17 December 2021
Job No: 20214_Response to Council_REV2

Re: Huntingwood Processing Facility – SSD 17352813 - 65 Huntingwood Drive, Huntingwood

We Sparks & Partners Consulting Engineers being the civil/stormwater engineer for the above proposed development have reviewed the comments provided by Council dated 16th November 2021 and provide the following responses regarding DPIE & Council concerns to assist in the SSDA assessment.

DRAWING TITLE			
CIVIL DESIGN CONCEPT SITEWORKS & STORMWATER MANAGEMENT BASEMENT (B2) PLAN			
DATE	DRAWN	DESIGNED	CHECKED
FEB 2021	MG	DD	BB
PROJECT No	SCALE	SIZE	REVISION
20214	1:250	B1	
DRAWING No			
DA4111			6

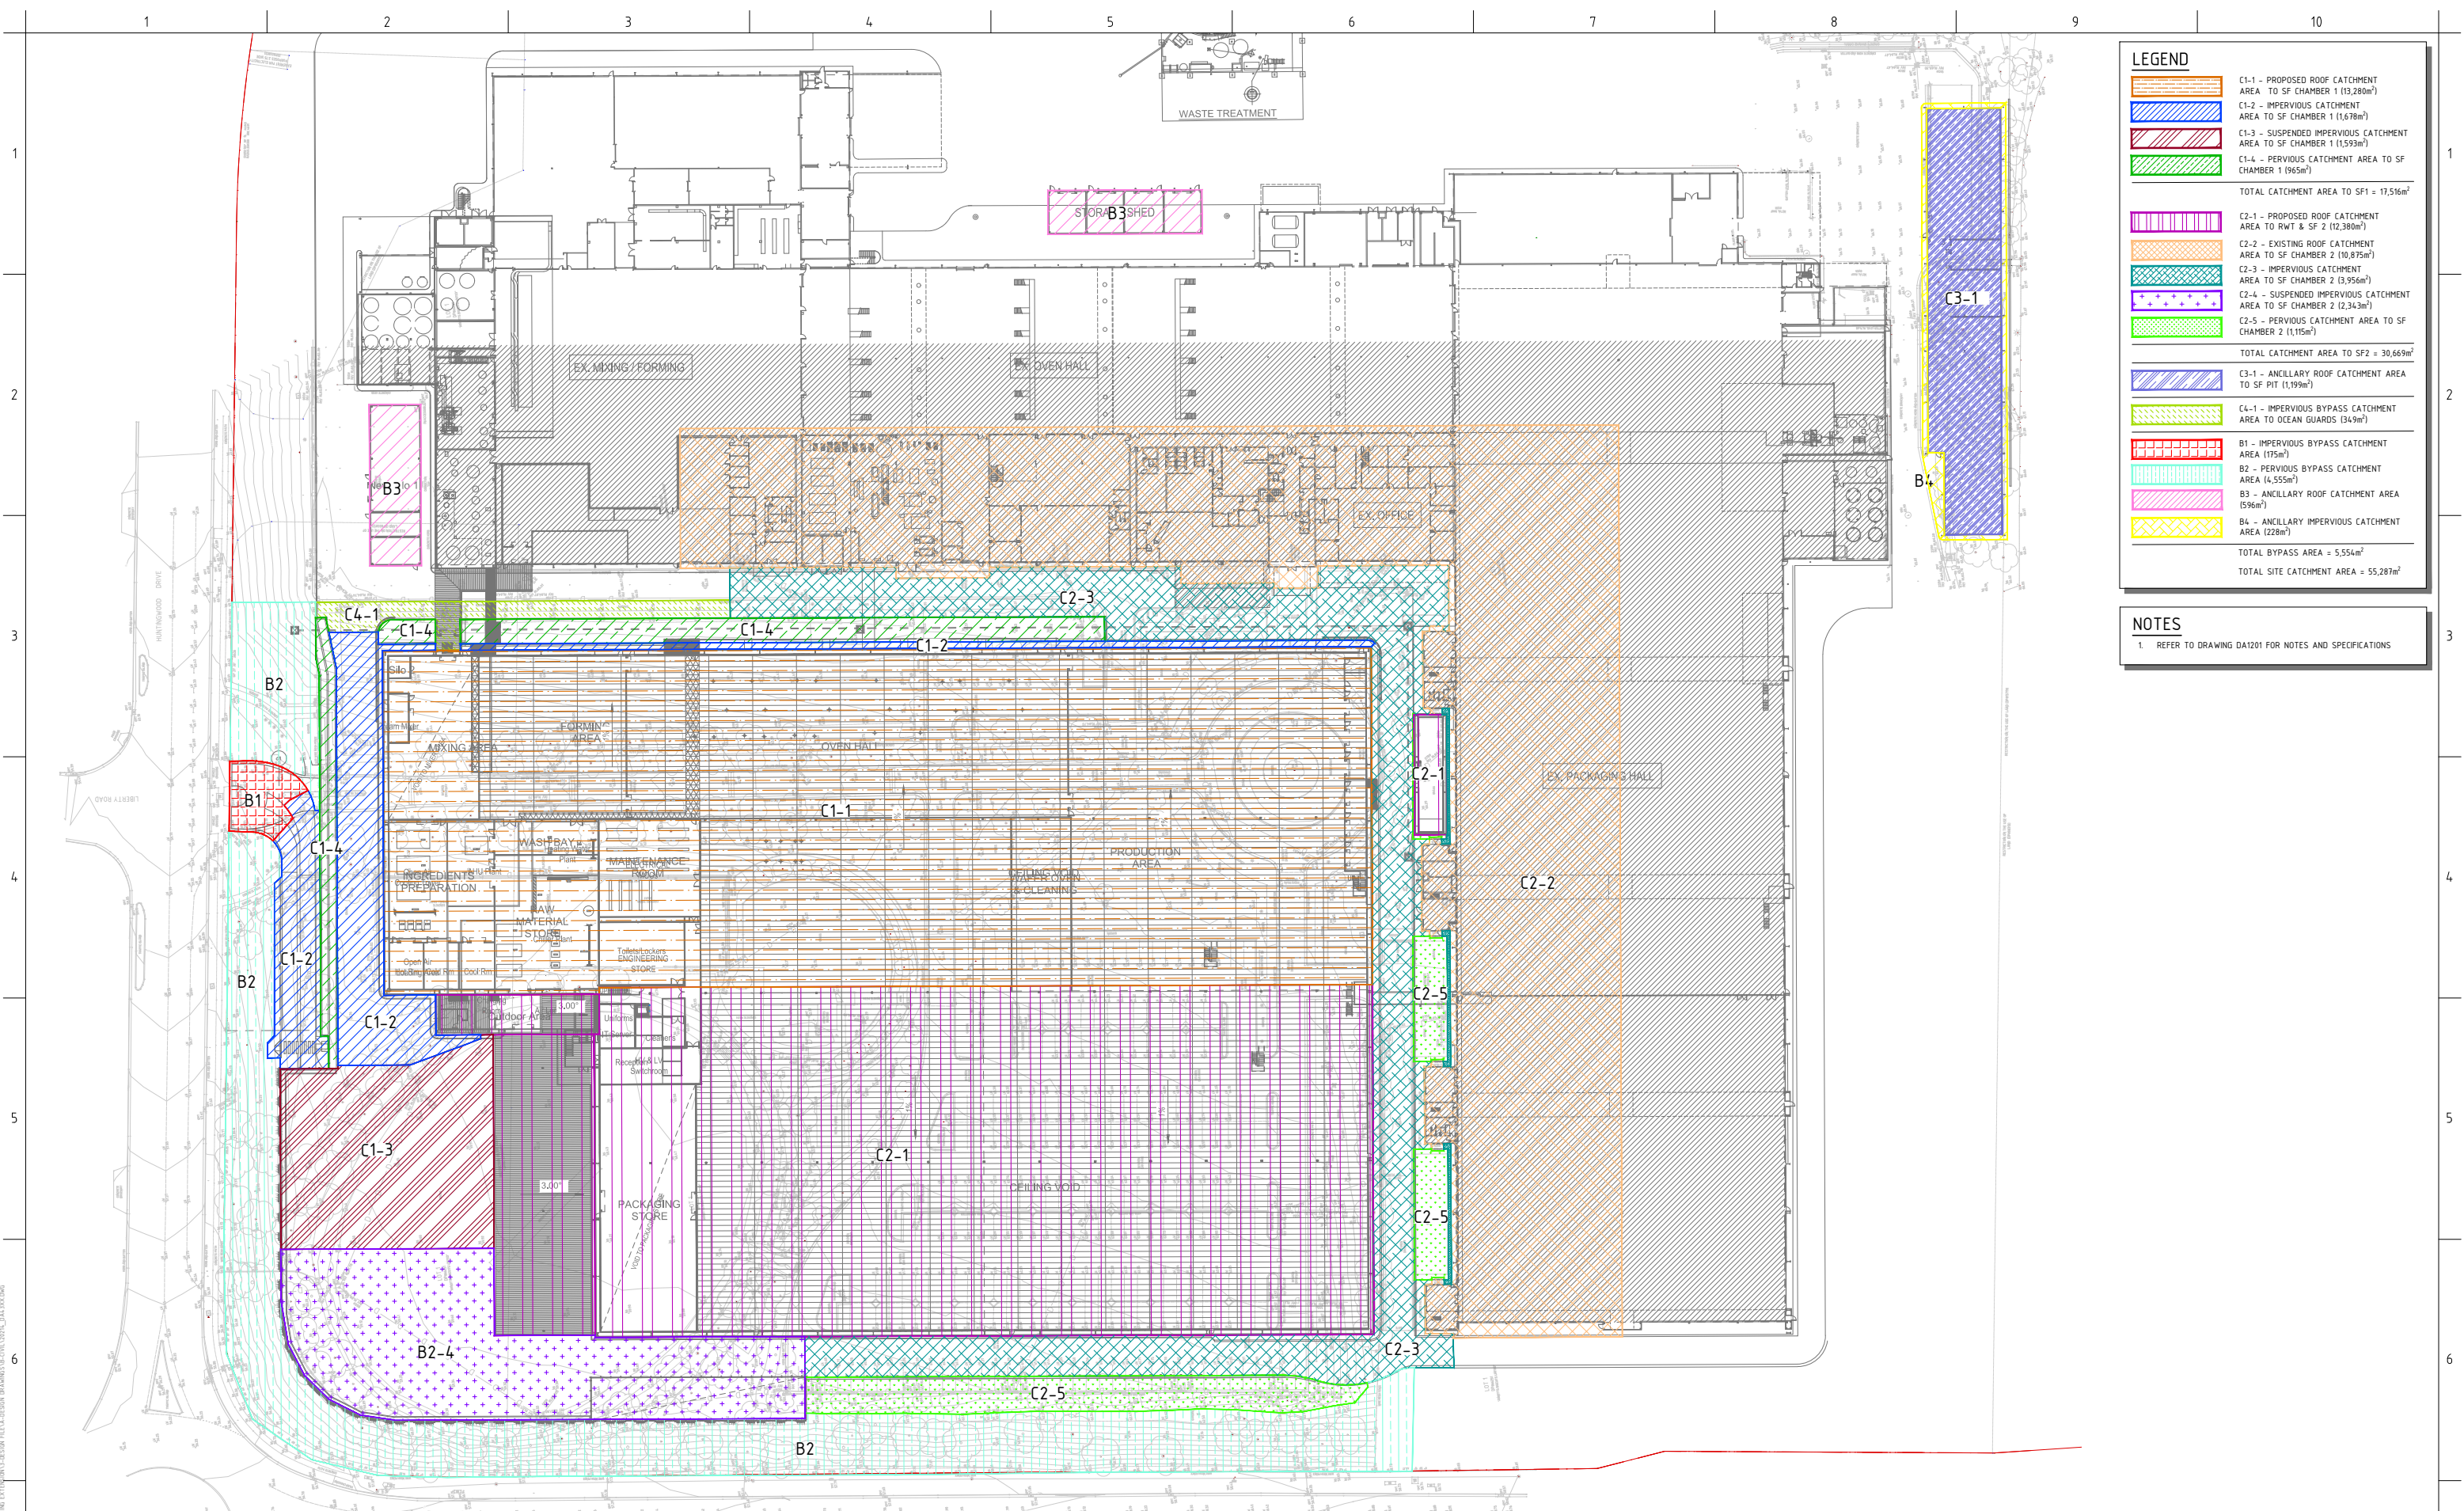
<p>f) <i>Provide details of the first flush pit (this is to be sealed)level by calculating the upstream and downstream pit's invert level.</i></p>	<ul style="list-style-type: none"> Detail is provided on DA4702 and on plan DA4111.
<p>g) <i>Uncovered (no roof above) On-Site Detention area is to be considered bypass for water quality</i></p>	<ul style="list-style-type: none"> OSD is covered by upper floors and has no direct rainfall.
<p>Water Quality</p>

CIVIL DESIGN  
 CONCEPT STORMWATER WSUD  
 CATCHMENT PLAN

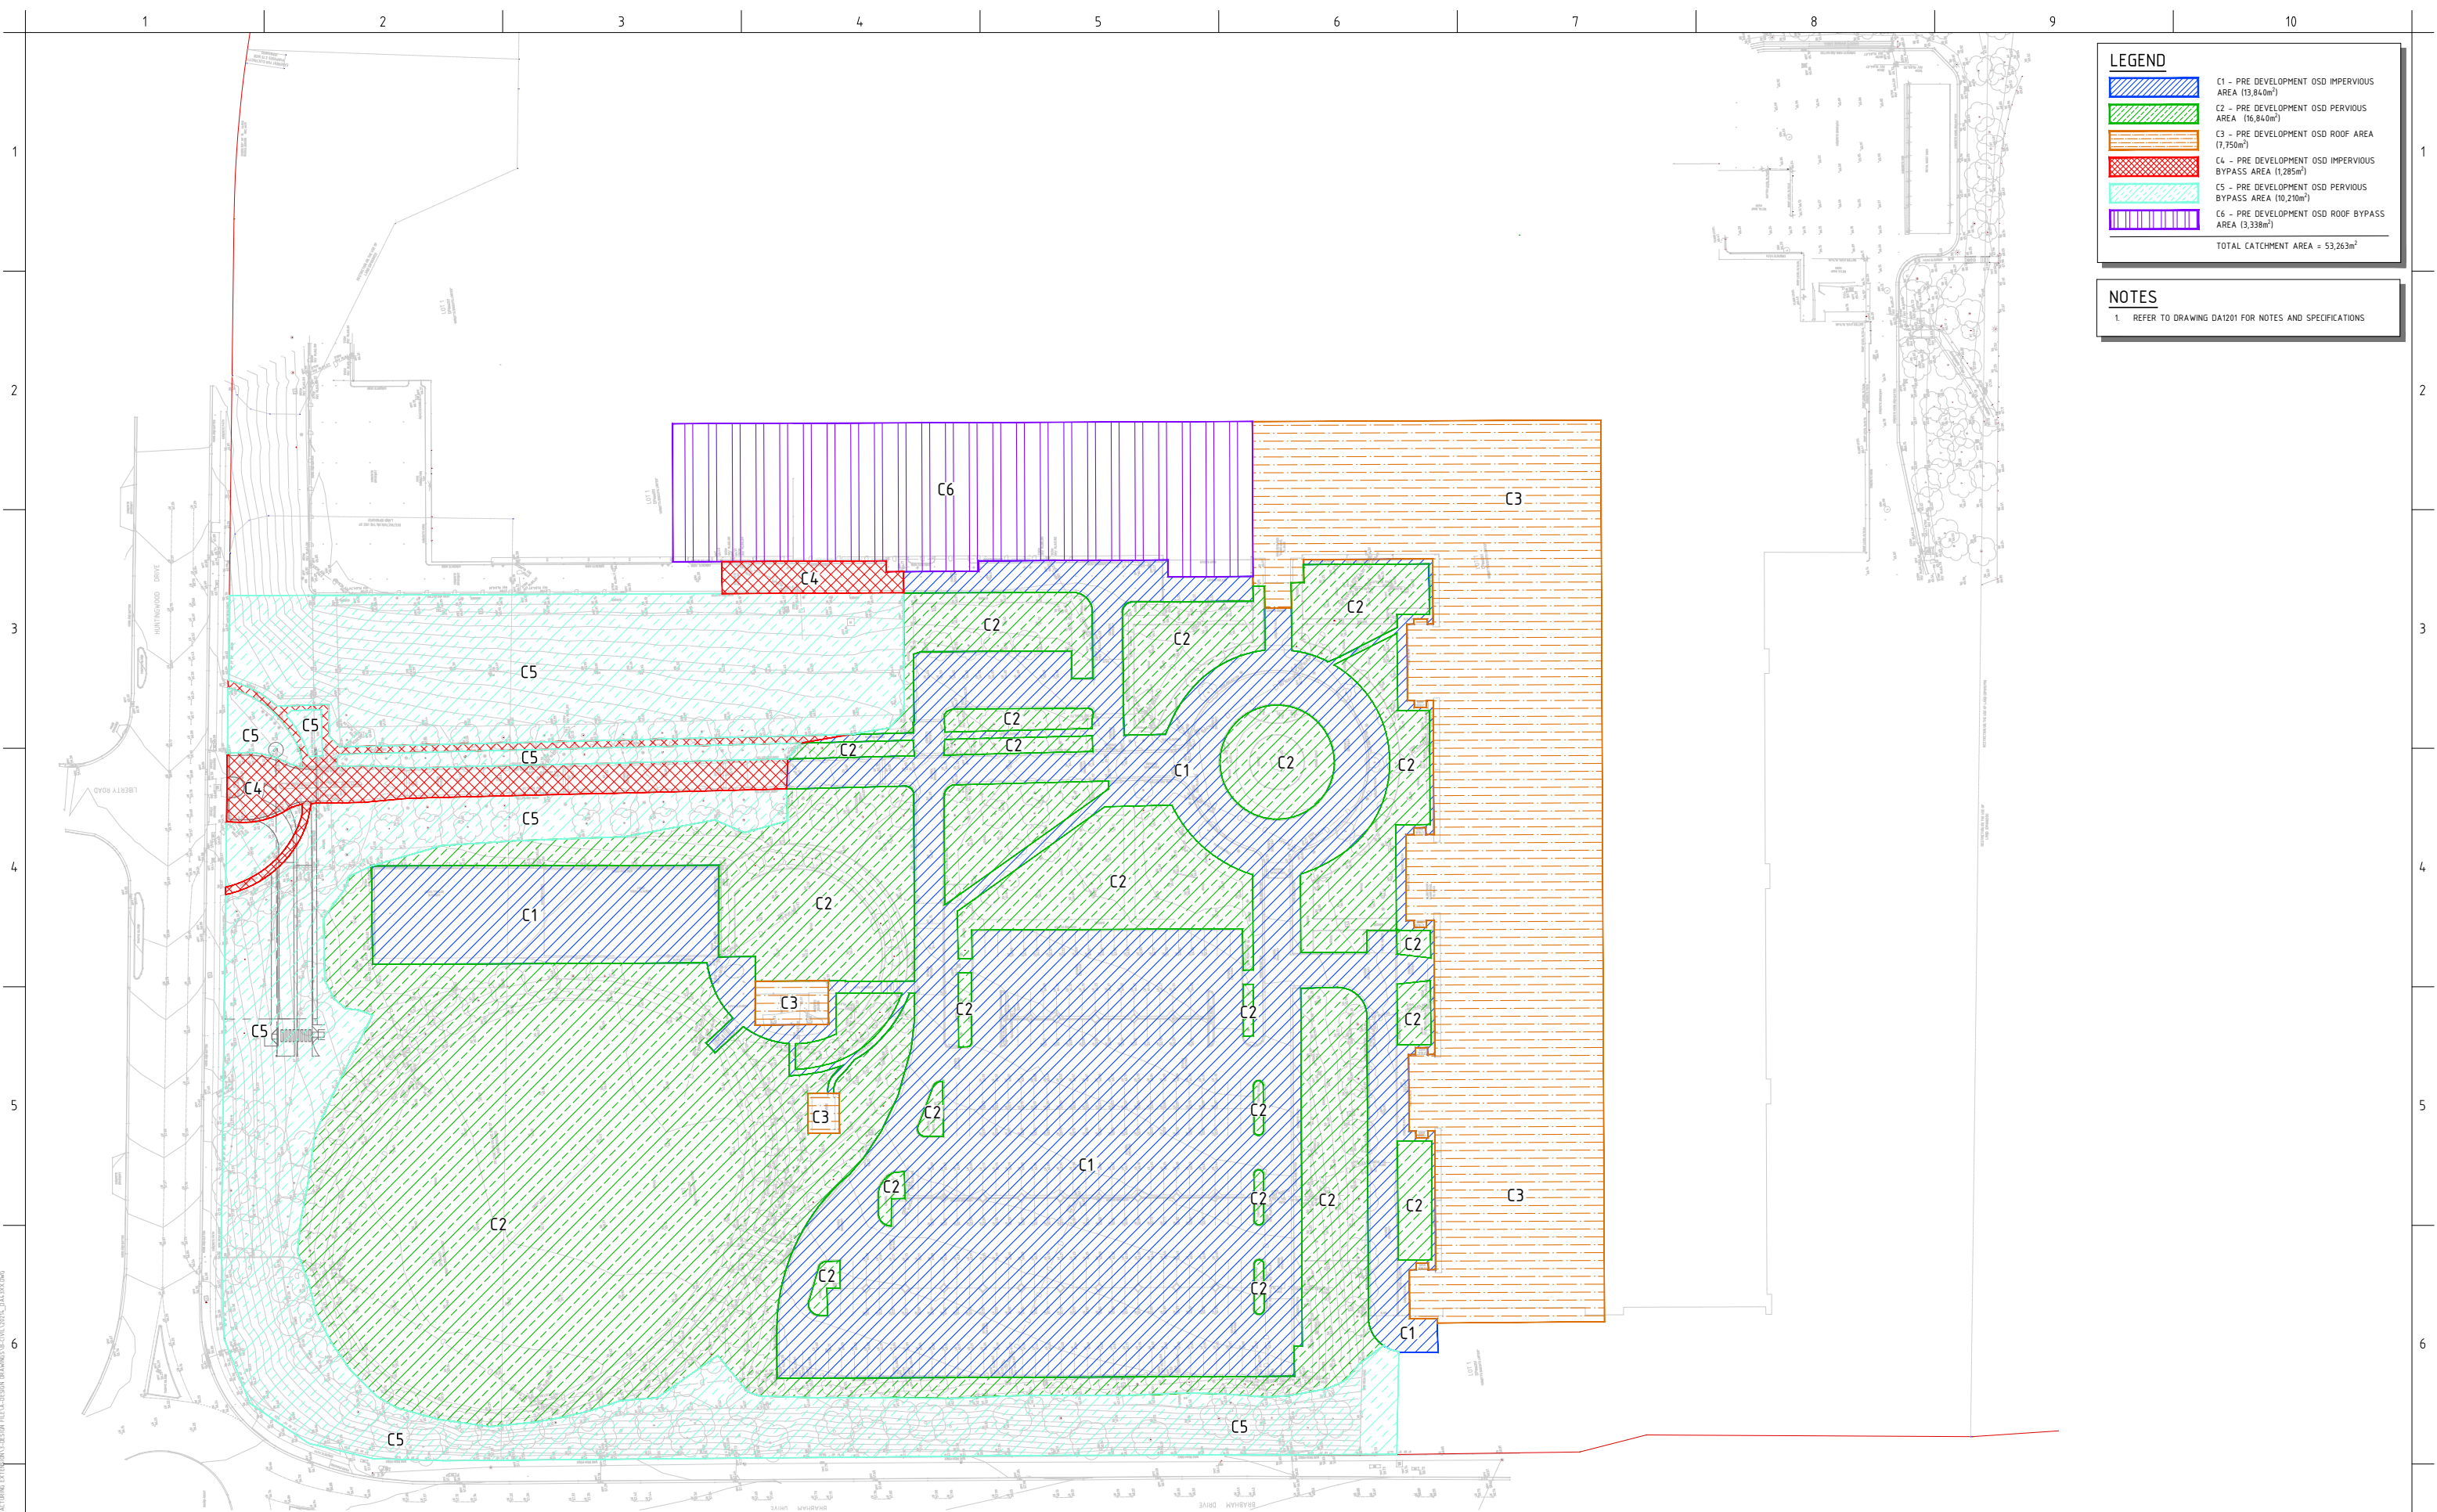
<p>a) Water Quality applies to all the development including ancillary buildings such as 'processing building (BLDG)', storage shed, Silo 1 and 2. This is independent of On-Site Detention requirements. Further details are to be provided regarding water quality for the aforementioned buildings</p>	<ul style="list-style-type: none"> • Silo and storage shed drains to a system with no treatment and considered as bypass. • Chocolate building roof is treated by a separate Stormfilter chamber. Refer to DA4104 & DA4702.
<p>b) It appears that on Dwg. DA4301 ancillary catchment (1790 + 313m²) are unaccounted for. These are to be either treated or considered as bypass for Water Quality. Confirm water quality approach regarding the ancillary catchment (1790 + 313m²) as shown on Dwg. DA4301.</p>	<ul style="list-style-type: none"> • Areas are accounted for in the design. Refer to WSUD catchment plan DA4301 and IWCM Report.

<p>c) Model for Urban Stormwater Improvement Conceptualisation 'X' is not yet supported and a standard Model for Urban Stormwater Improvement Conceptualisation model is to be submitted.</p>	<ul style="list-style-type: none"> • MUSIC V6 model has been provided.
<p>d) Ensure Model for Urban Stormwater Improvement Conceptualisation model matches the plans in terms of names, abbreviations, areas and land use.</p>	<ul style="list-style-type: none"> • Catchment plans have been noted with prefixes to more clearly link the catchment plan and MUSIC model.
<p>e) Label each sub-catchment on Dwg. DA4301 i.e. on top of the hatchings for ease of identification.</p>	<ul style="list-style-type: none"> • Labels have been added to all catchment plans.
<p>f) Provide information on the total catchment area for 'SF1, SF2, bypass for water quality.</p>	<ul style="list-style-type: none"> • Total catchments to each chamber are more clearly noted in the catchment plan DA4301.

**JELLYFISH JF2250-12-2 & DIVERSION PIT - DETAIL**  
SCALE 1:50

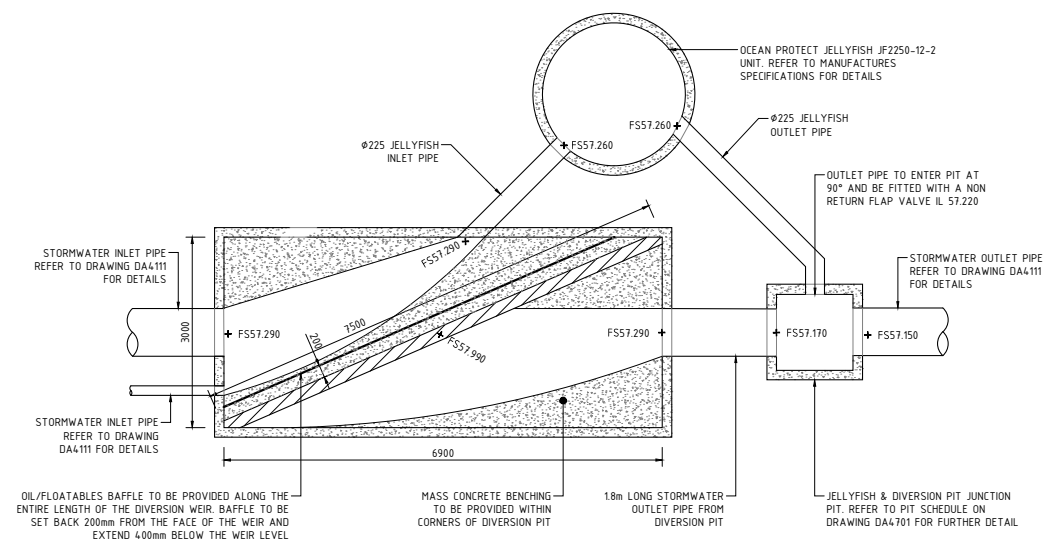
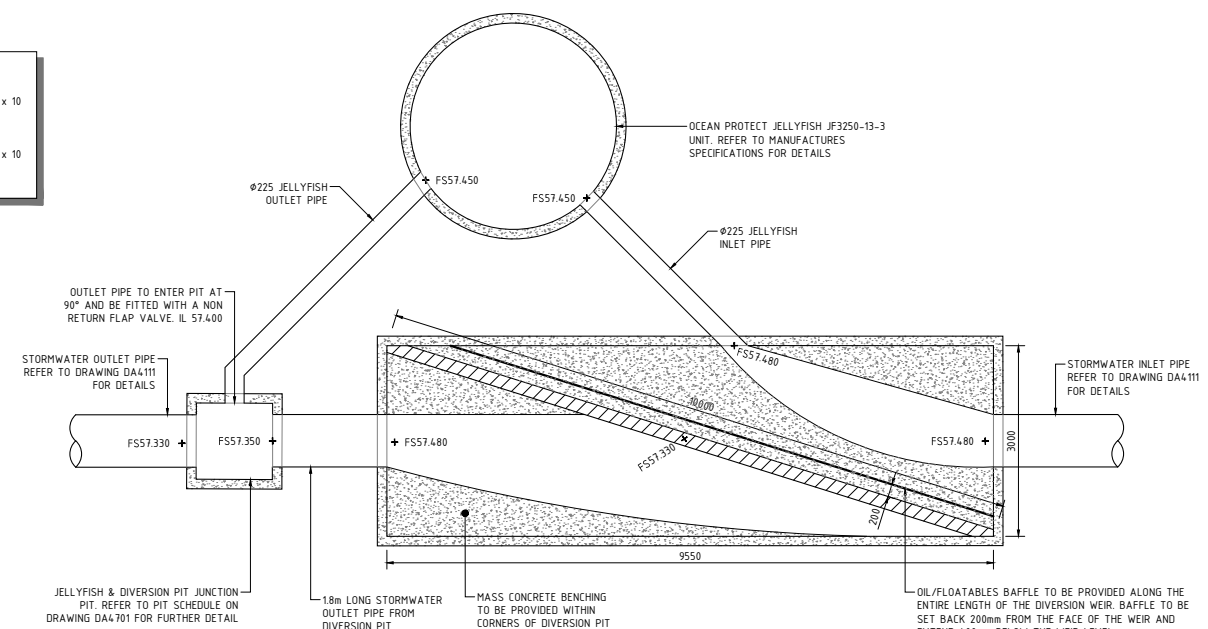
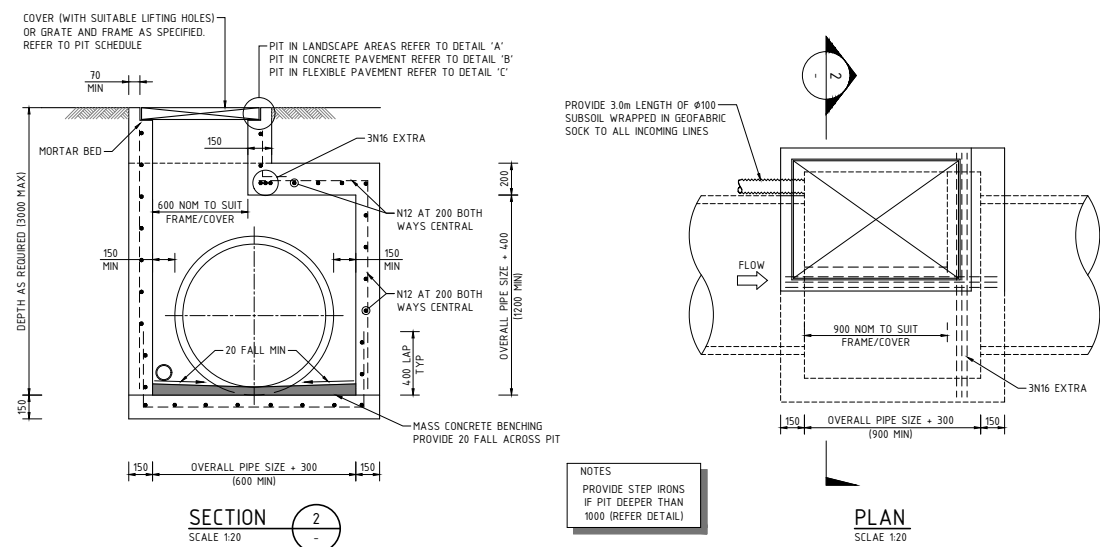
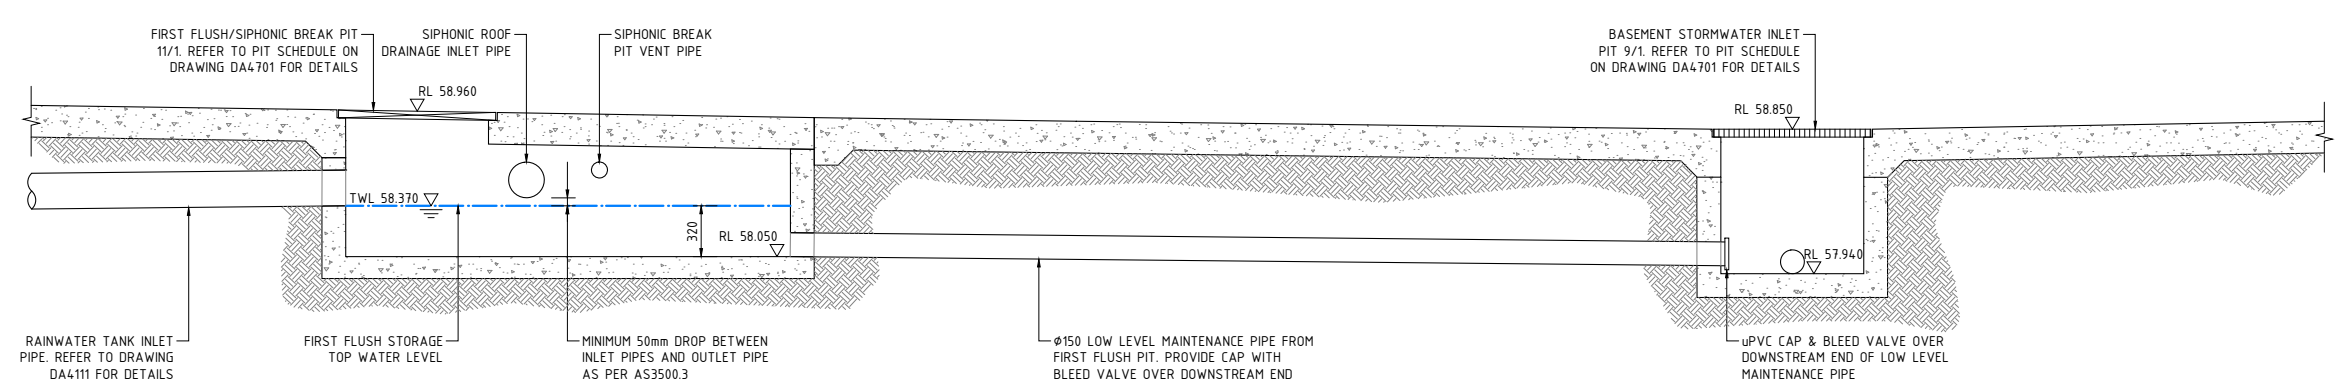
<p>g) Jellyfish calculations, detailed drawings, levels and splitter pits are to be provided to as per the Water sensitive urban design developer handbook chapter 12.13.</p>	<ul style="list-style-type: none"> • Jellyfish detail and calculations are provided on DA4702.
<p>h) All pits with OceanGuards are to be clearly noted on the plan.</p>	<ul style="list-style-type: none"> • Pits with Oceanguard are noted within a pit schedule on DA4701.
